CITY OF ALBUQUERQUE

December 21, 2015

**Re: O'Reilly Auto Parts 12700 Lomas Blvd NE
Erosion Sediment Control Plan
Engineer's Stamp Date 12-14-15 (K22E019)**

DRAWN: MRR
CHECKED: NSB
DATE: 12-11-2015
JOB NO.: 315621 (A15)
SHEET: C4
SHEET 5 OF 6

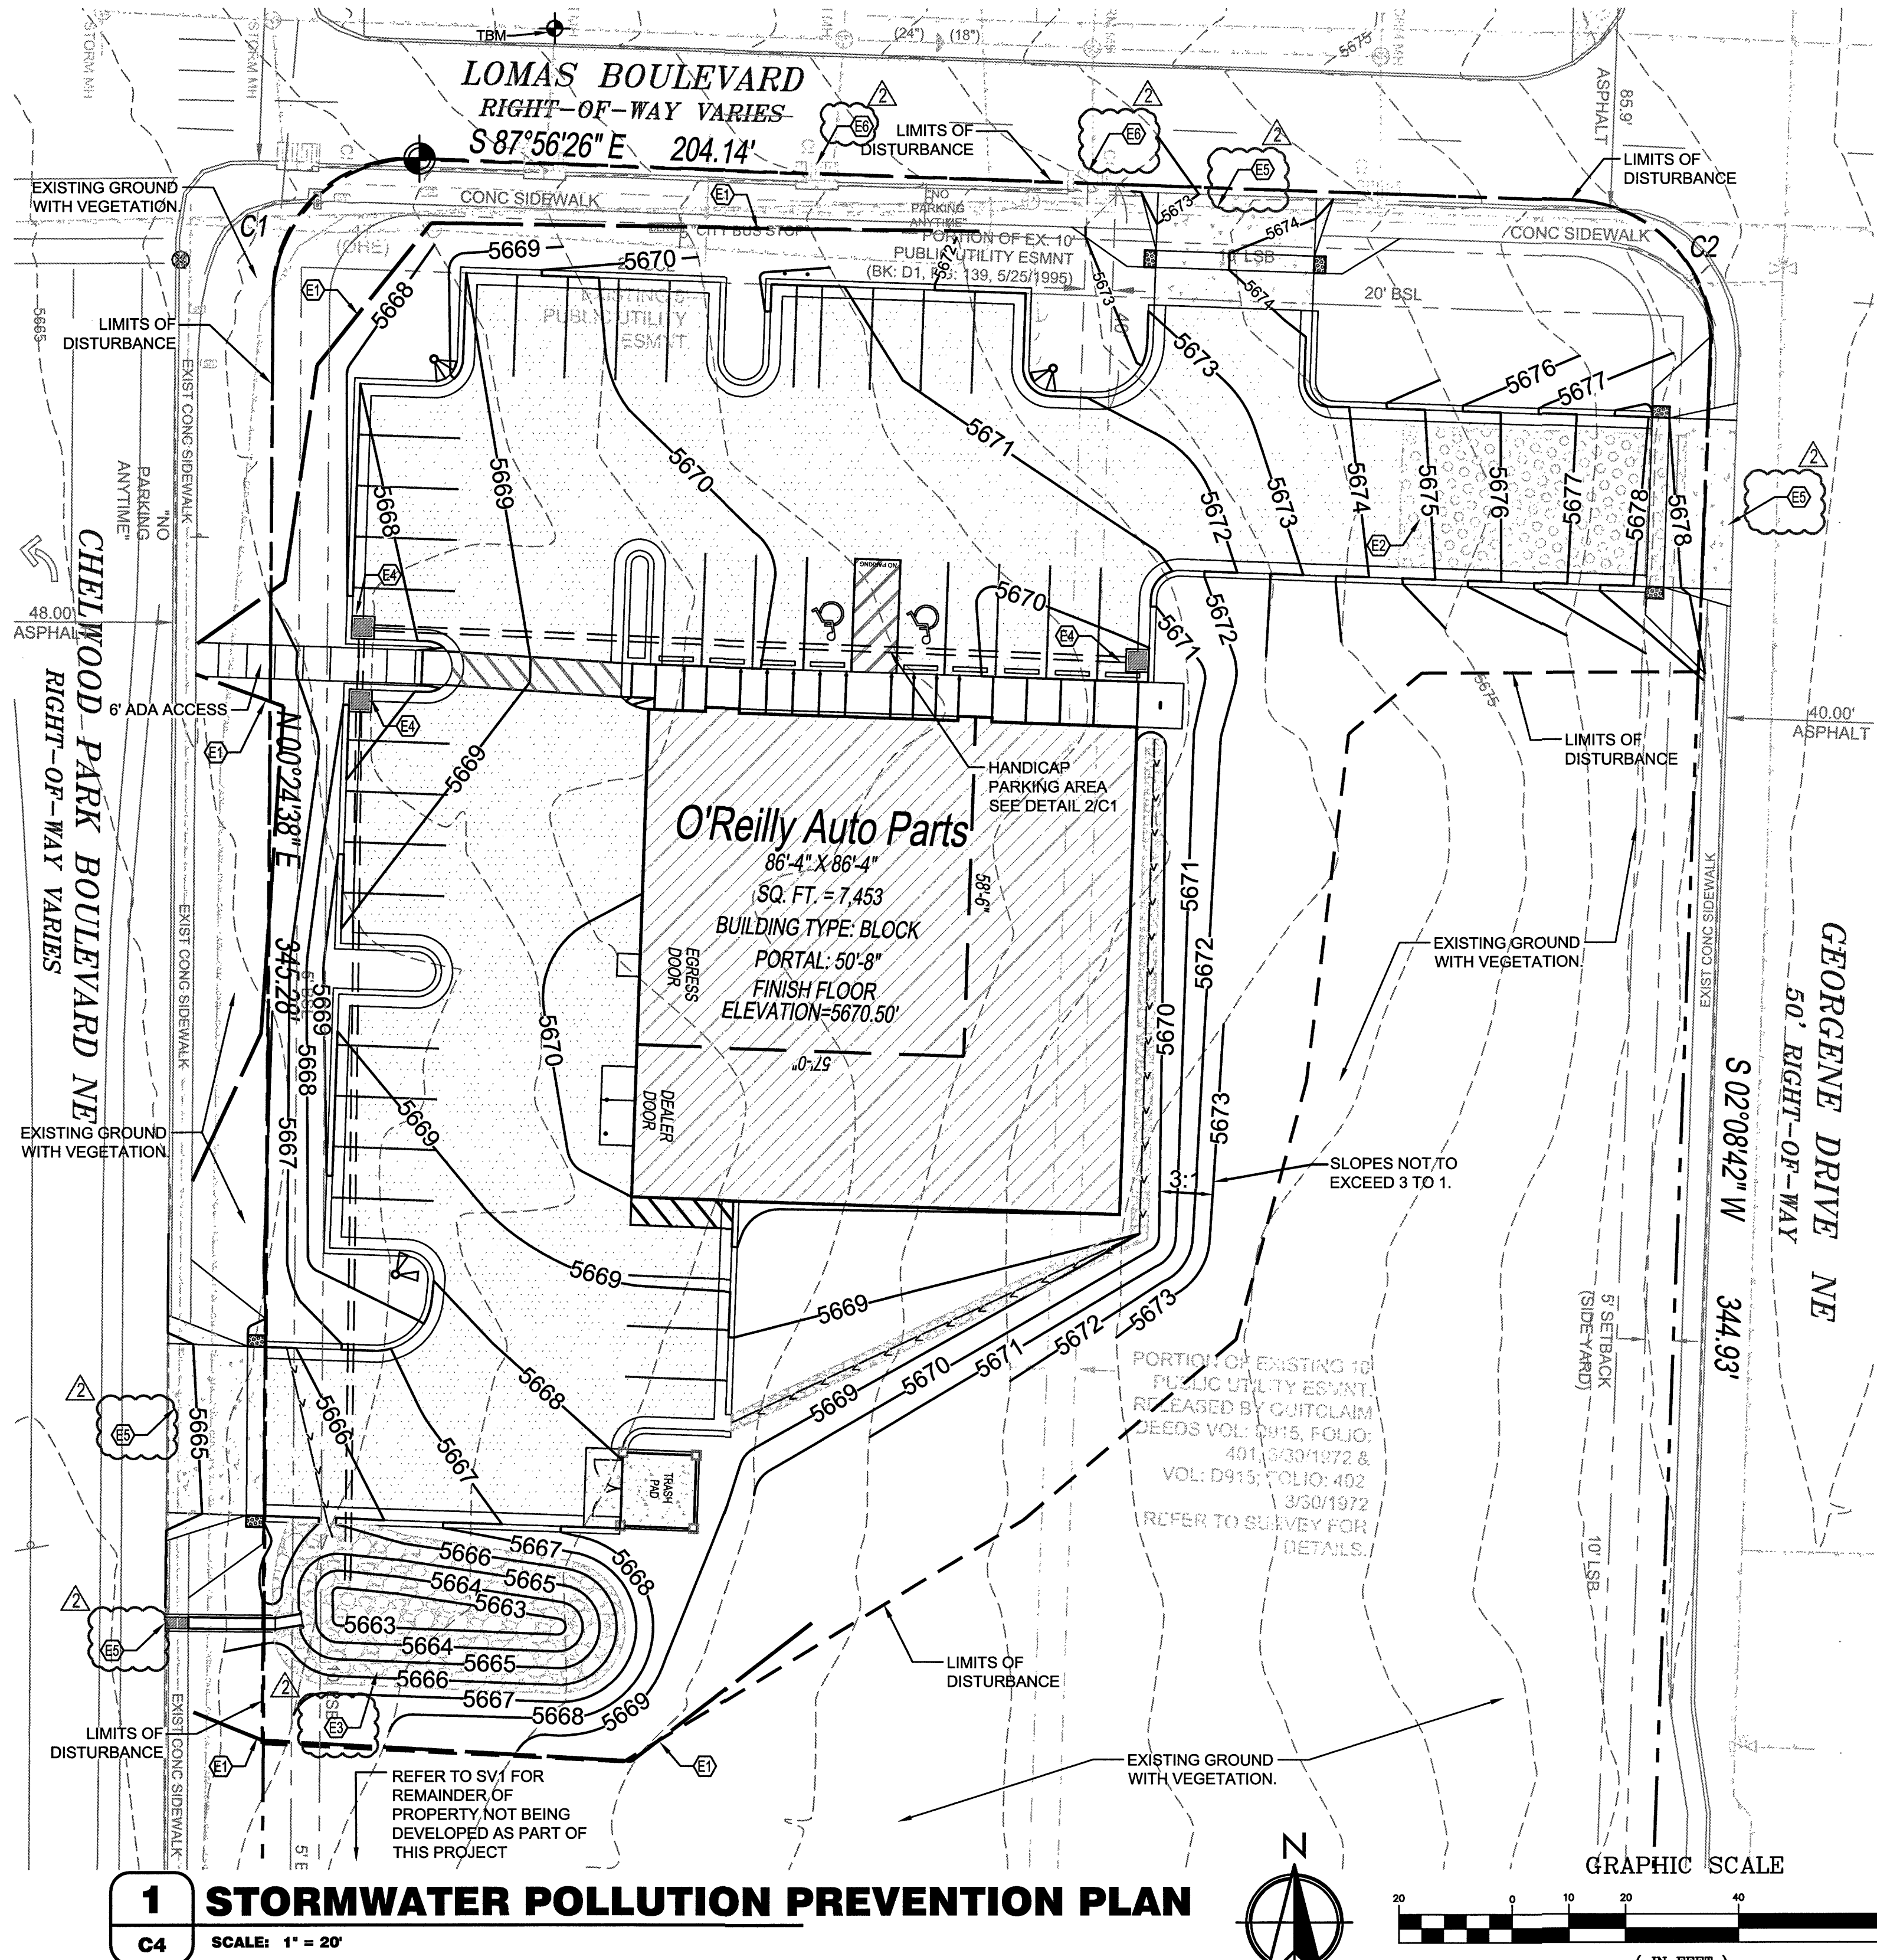
1. Add a note near the proposed drive entrances and sidewalk culvert that the street in the area is to be swept daily when working in the City ROW if sediment is present.
2. Add inlet protection for the two inlets downstream of the entrance on Lomas Blvd, when the drive entrance on Lomas Blvd is being constructed. Inlet protection should be placed in the gutter pan upstream of the inlet that leaves the inlet open for flood control purposes. An example is attached to the e-mail.
